RE: Harnett County Land Use Application HTE # 05-5-12830
*Note pool has already been installed!

The Harnett County Department of Public Health, Environmental Health Division on August 18, 2005 evaluated the above referenced property at the site designated on the plat/site plan that accompanied your existing tank application. According to your application requesting a swimming pool, the evaluation was done in accordance with the laws and rules governing wastewater systems in North Carolina General Statute 18A.1950 including related statutes and Title 15A, Subchapter 18A, of the North Carolina Administrative Code, Rule.1950 and related rules.

Based on the criteria set out in Title 15A, Subchapter 18A, of the North Carolina Administrative Code, Rules .1950, the evaluation indicated that the site is **UNSUITABLE** for the addition requested. Therefore, your request for an existing tank is **DENIED**. The site is denied based on the following:

IMPROVEMENT PERMIT 22304

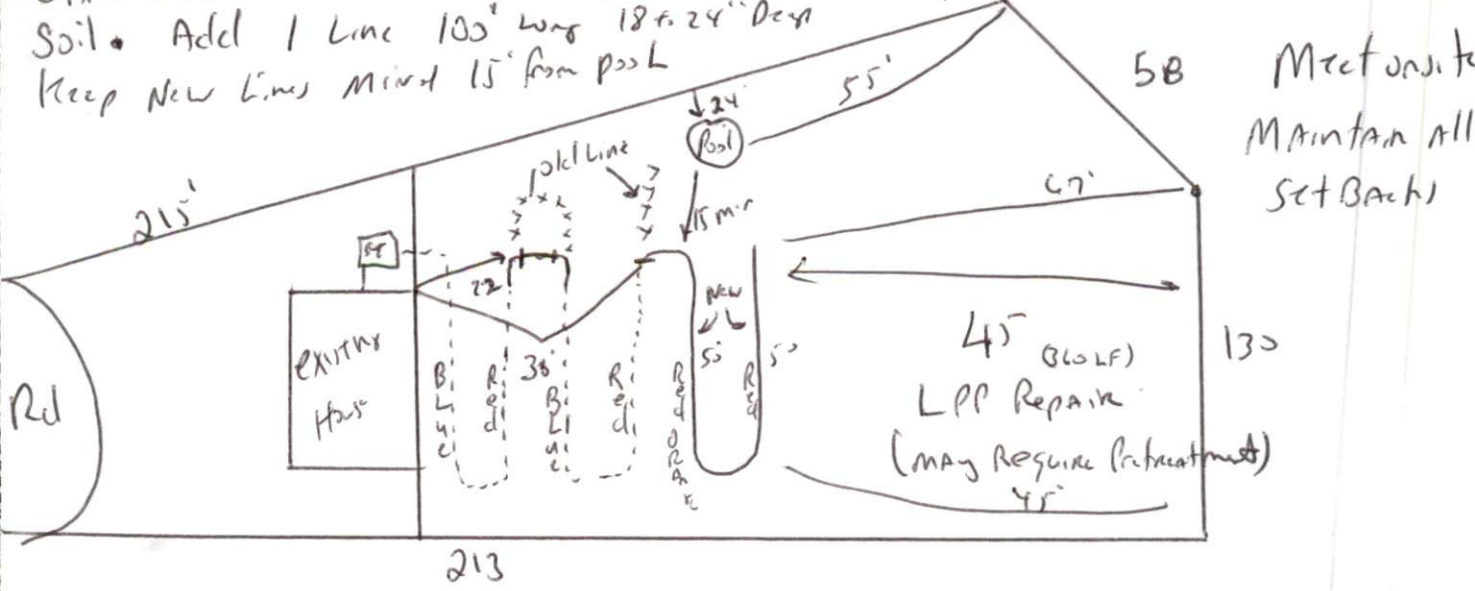
- 15A NCAC 18A.1950 a(16) Any swimming pool must be 15' from any part of septic system.**
- 15A NCAC 18.1945 (b) Each lot shall have original septic system plus repair area.**
- 15A NCAC 18A.1950 (10) – Any building to be 5' from drain line.**
